October 12, 2023

Re: White Barn – Chick-fil-A – *Technical Review 1*
PA23019

After reviewing the application materials for the above referenced proposal, the following technical review comments are provided below.

SHEET **PRELIMINARY SITE PLAN**

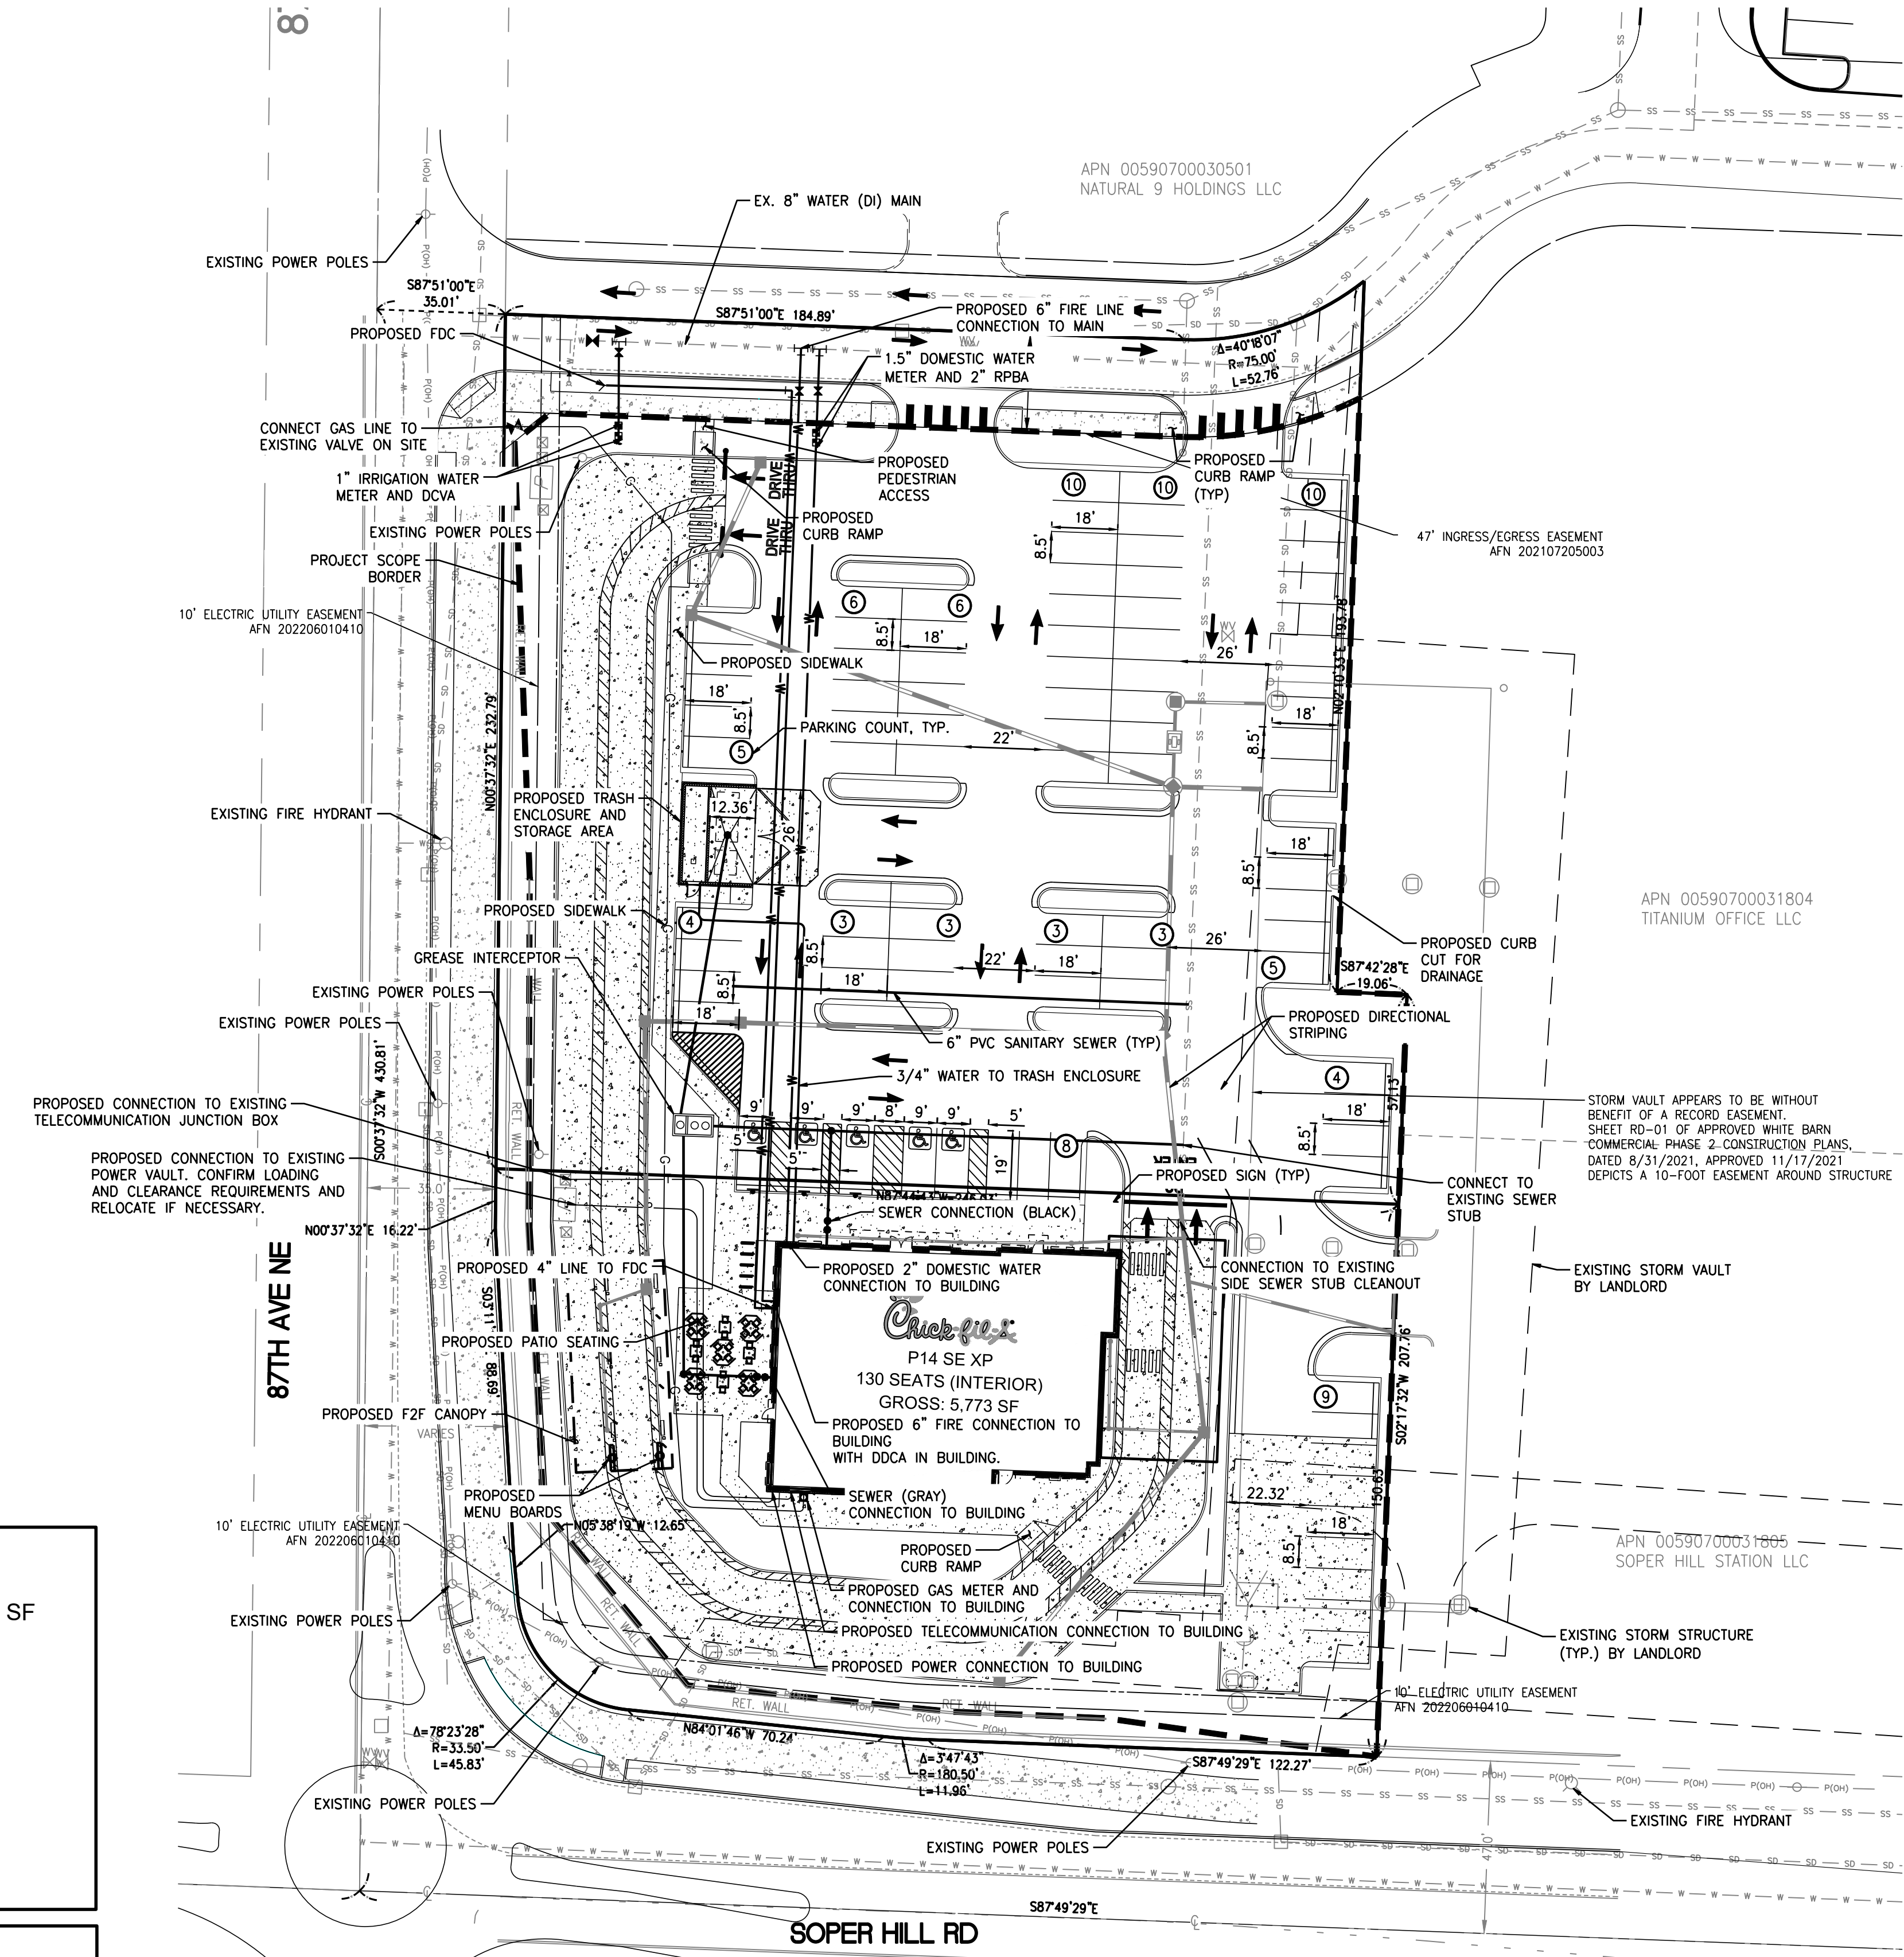
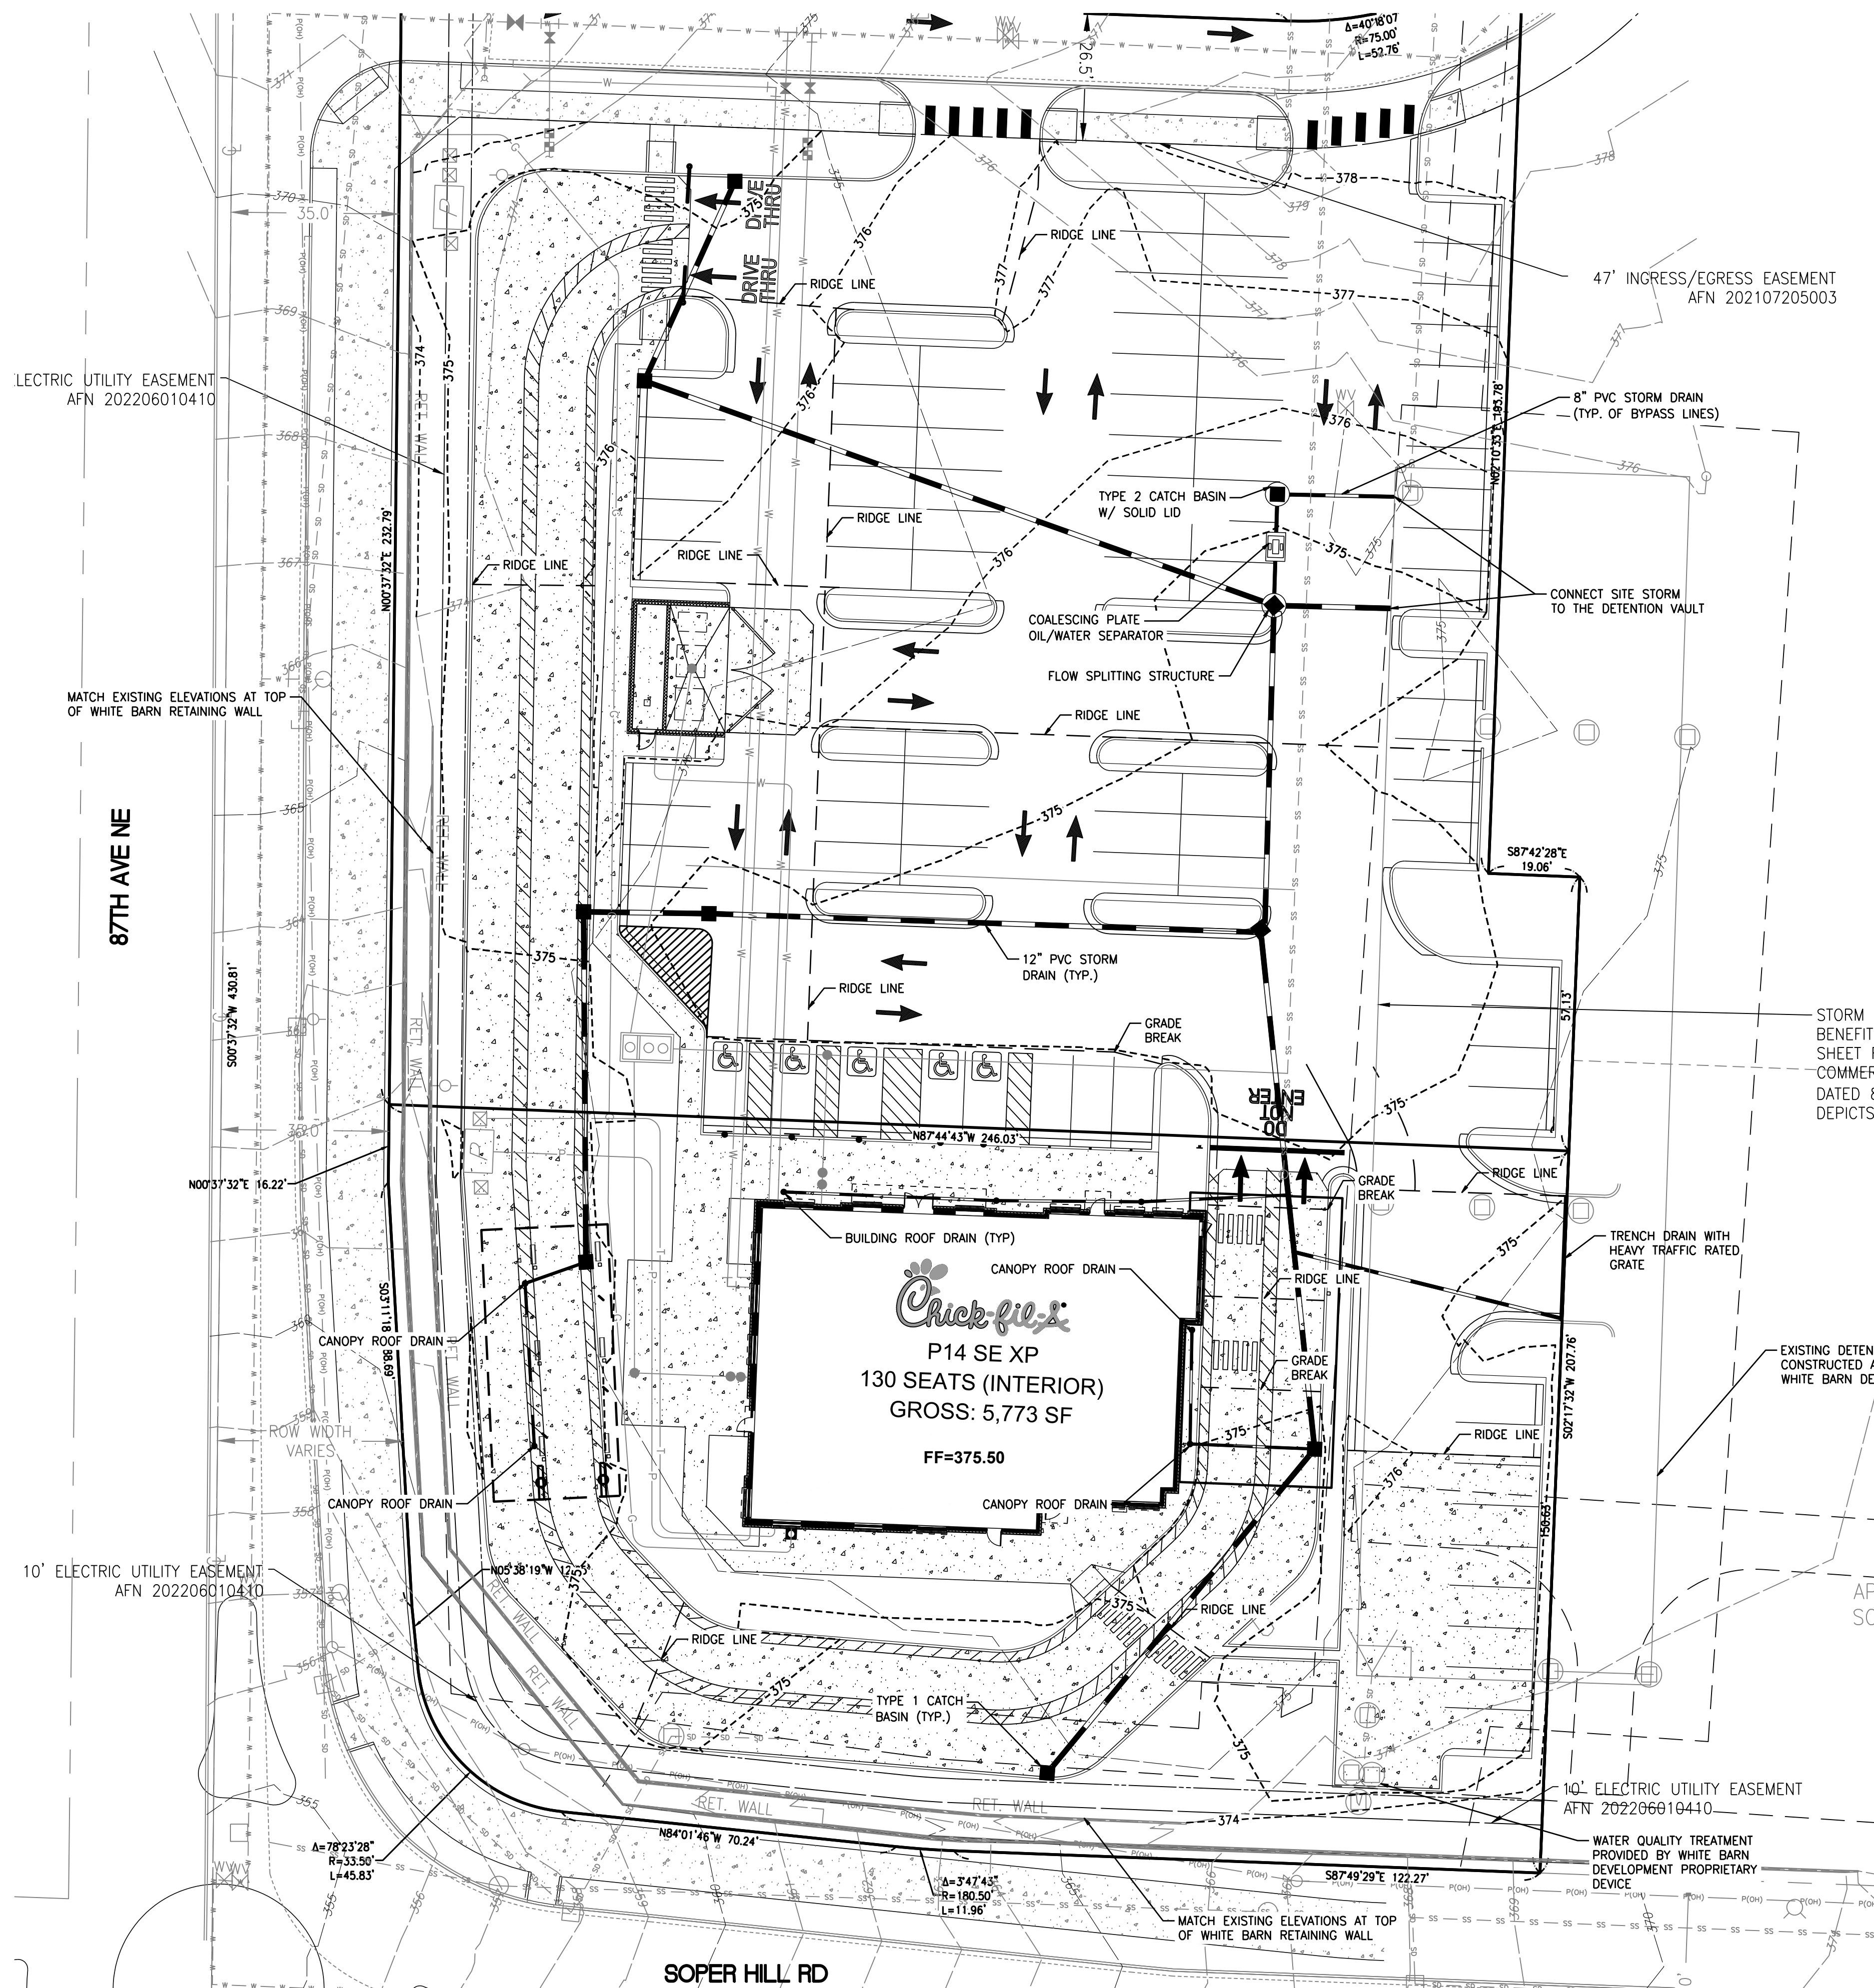
1. Provide file number PA23-019 on all future plan submittals.
2. Sheet C1.0 is too busy to review. Provide a clean version, by removing a majority of the notes and arrows, so staff can review to determine compliance with the applicable design standards and setbacks. Once a clean version is received staff will provide comments on the site plan. The following comments that were provided during pre-application review still apply:

- a. Provide the required 30' L3 buffer on Soper Hill Road and 87th Avenue NE.
 - b. Provide the required 20' L3 buffer along the eastern boundary of the property.

- c. Provide the required 15' L2 landscape buffer between Soper Hill Road and 87th Avenue NE drive-thru lanes. This can be incorporated into the required within a portion of the required 30' L3 landscape buffer.

- d. Provide the required 5' wide L2 landscape buffer between the parking areas and drive-thru. It appears a pedestrian sidewalk is proposed instead of the required landscaping.

- e. Provide a minimum 5' wide L1 landscape buffer around the proposed dumpster enclosure.
 - f. The applicant will need to ensure the size of the dumpster enclosure fits their needs. Sanitation does not provide service on Saturdays. Contact Kristy Beedle, Sanitation Supervisor, phone: 360.363.8152 email: kbeedle@marysvillewa.gov, for additional information.

- g. No more than 50 percent of the 87th Avenue NE frontage may be occupied by vehicular access or parking.

- i. Both motor vehicle and pedestrian cross access will be required from the Soper Hill Station to Chick-fil-A. Provide the pedestrian connection.
 - j. The pedestrian crossings along the north entrance shall be constructed with decorative concrete, similar to what has been installed on the White Barn development site. This detail will need to be provided.

- k. Provide required open space calculations. Non-residential uses shall provide pedestrian-oriented space, defined in subsection (2)(c) (see design standards for qualifications), at a rate of 2% of the site, plus 1% of the building floor area. Required sidewalks and walkways shall not count as pedestrian-oriented space. See [MMC 22C.070.100\(2\)\(c\)](#) for examples of qualifying pedestrian oriented open space.

- l. Add the following notes:
 - All necessary power lines, telephones wires, television cables, fire alarm systems and other communication wires, cables or lines shall be placed in underground location either by direct burial or by means of conduit or duct. All such underground installations or systems shall be approved by the appropriate utility company and shall adhere to all governing applicable regulations including, but not limited to, the applicable City and State regulations and specific requirements of the appropriate utility pursuant to [MMC 22G.120.270](#);
